PHILIP HEARD IP NUMBER [REDACTED]: FOSSE GREEN DEADLINE 3A SUMMARY

PHILIP HEARD IP NUMBER F86A1944A: FOSSE GREEN DEADLINE 3A COMMENTS

This submission covers the Applicant's comments in response to ExQ1 (REP2-029) and Deadline 1 Submissions (REP2-030), plus a final conclusion. Key takeaways include the Applicant's use of high load factors, underestimation of Greenhouse Gas (GHG) emissions, excessive overplanting of solar PV panels and failure to recognise permanent sealing of land.

FIGURE NUMBER REV.
Figure 3-2A SHEET 1 02

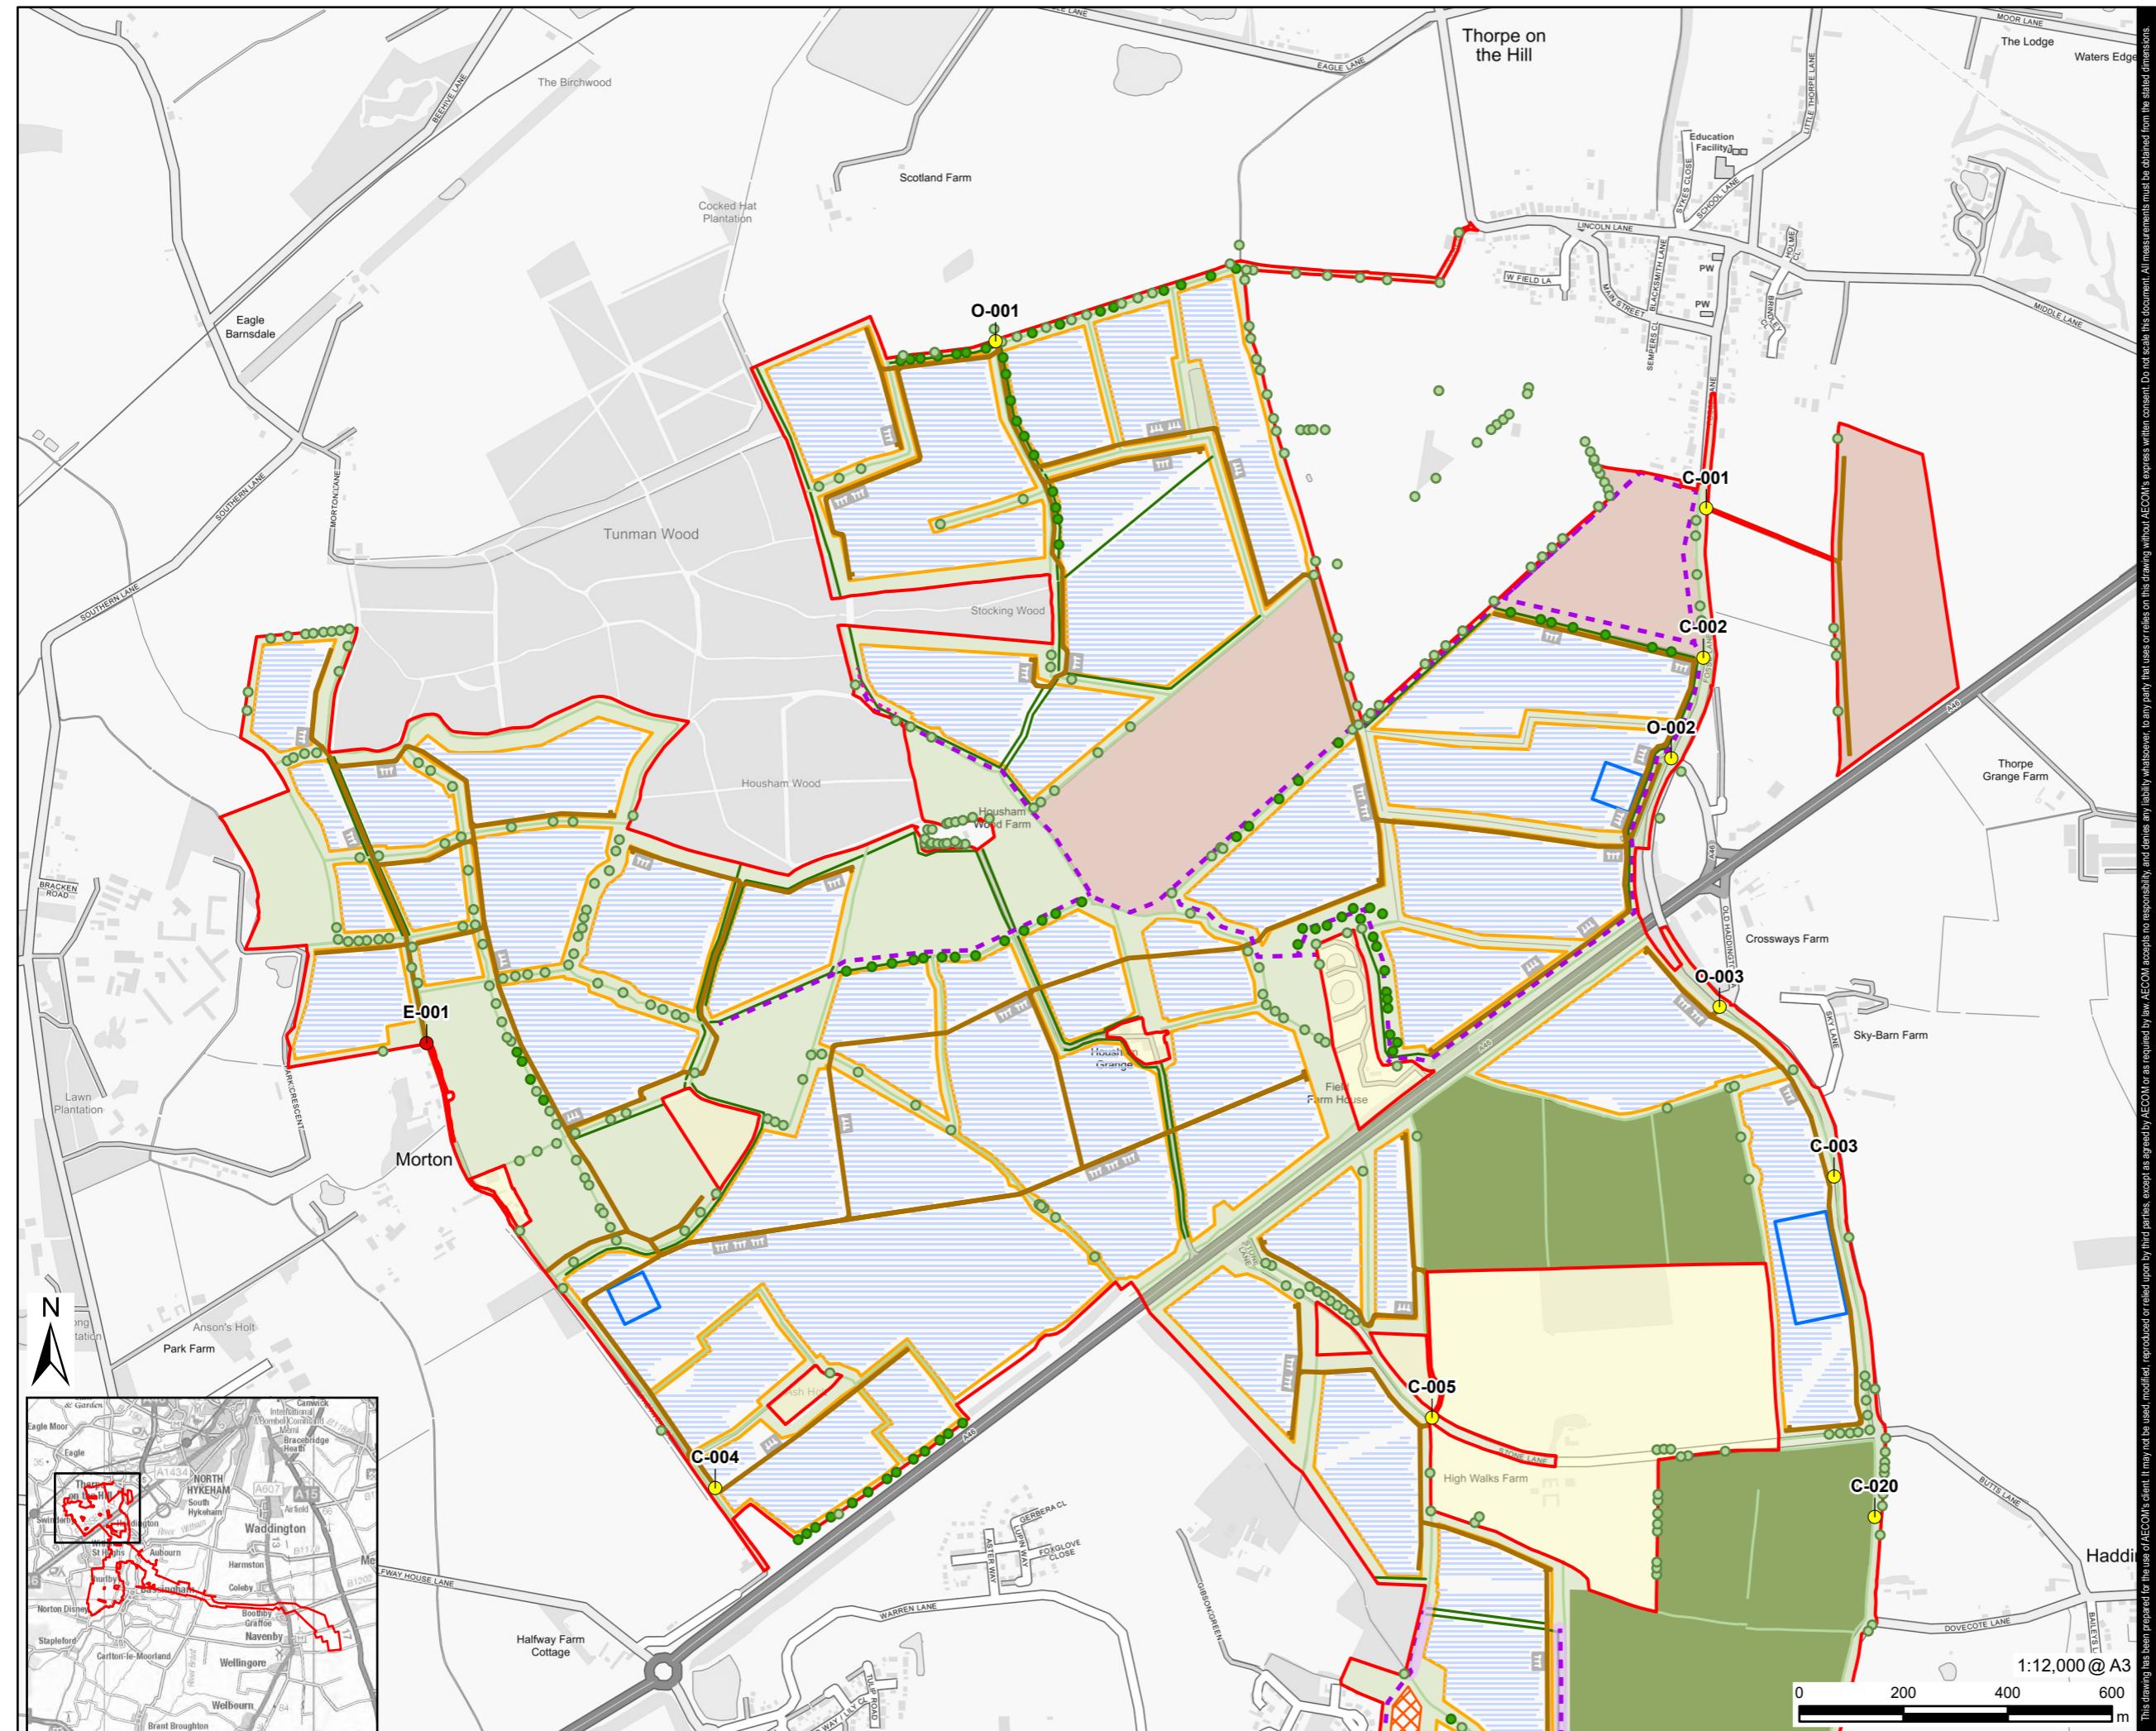
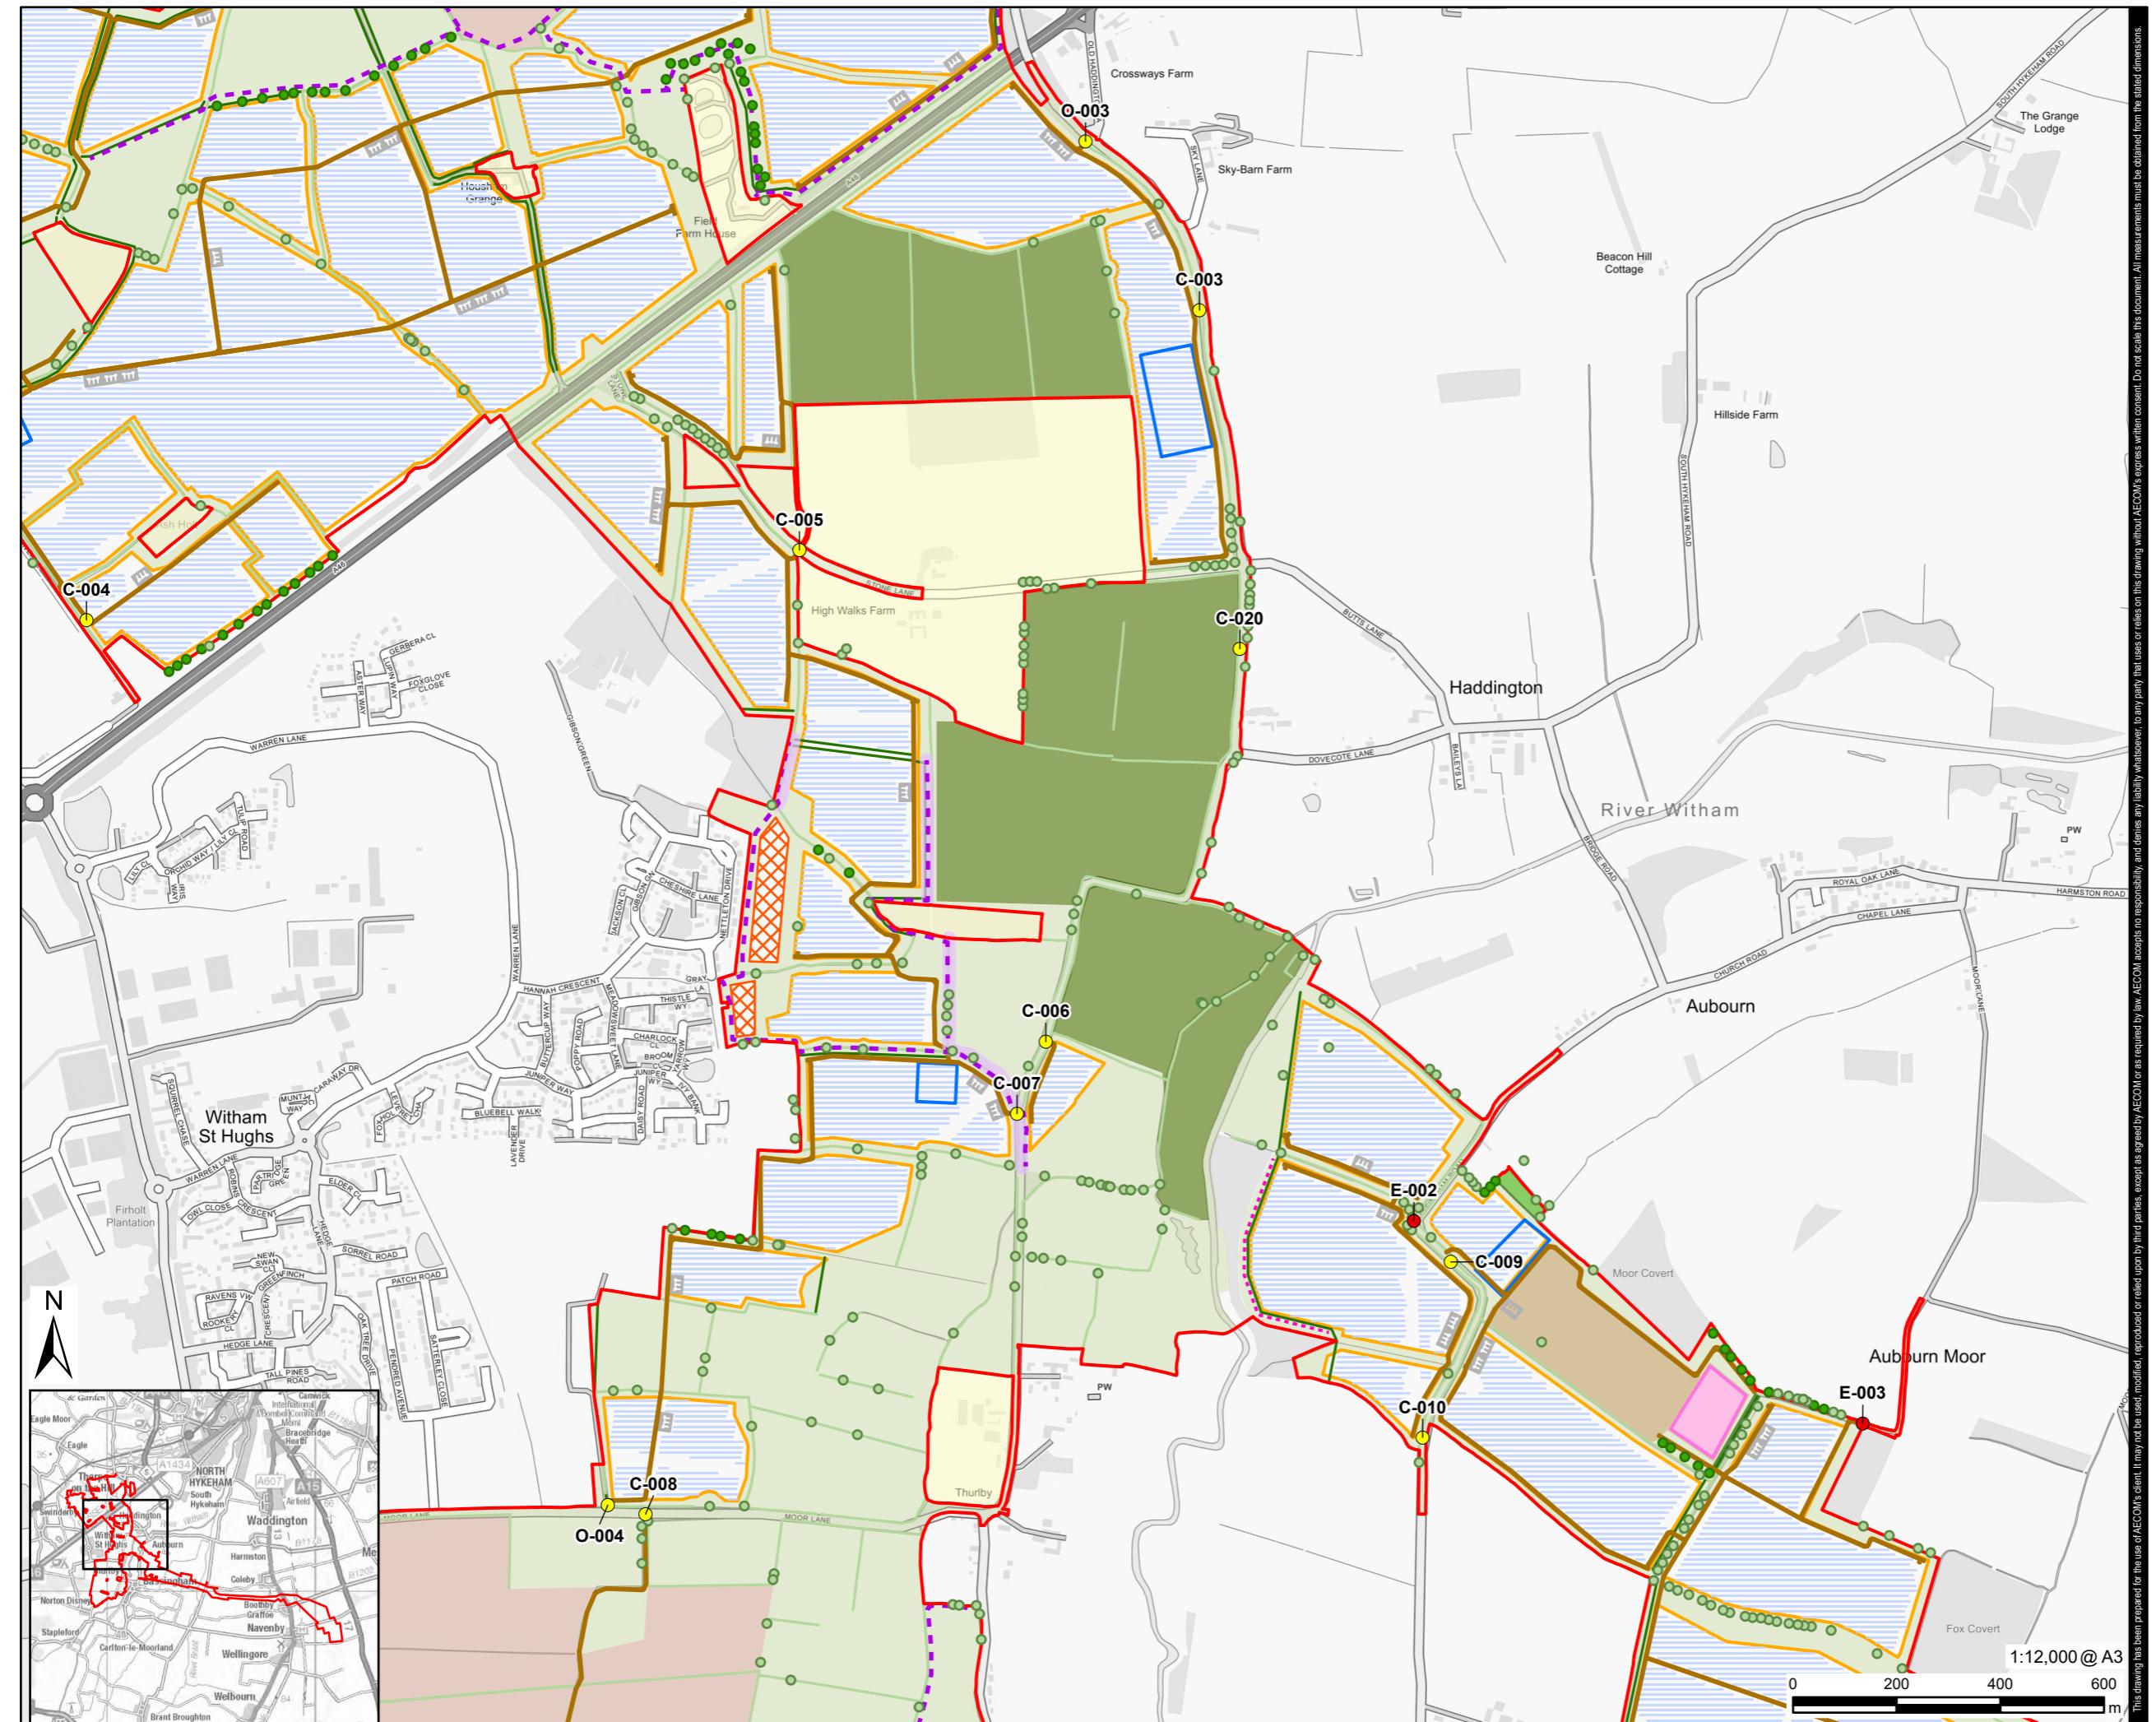
Regarding the overplanting ratio, the Applicant states "*adopting an overplanting ratio of 1.6 results in an overplanting ratio of 1.02 at year 30 when accounting for module degradation and Nominal Operating Cell Temperature (NOCT) conditions.*" Yet REP2-033, Table 5.2 for NOCT conditions commences at Year 1 with an overplanting ratio of 1.17 NOT 1.6. As REP2-033, Paragraph 5.3.1 states that NOCT better accounts for UK conditions, an overplanting ratio no greater than 1.2 can be justified. This results

in a reduction, for example of the fixed south facing option, of 139,250 panels to 426,750.
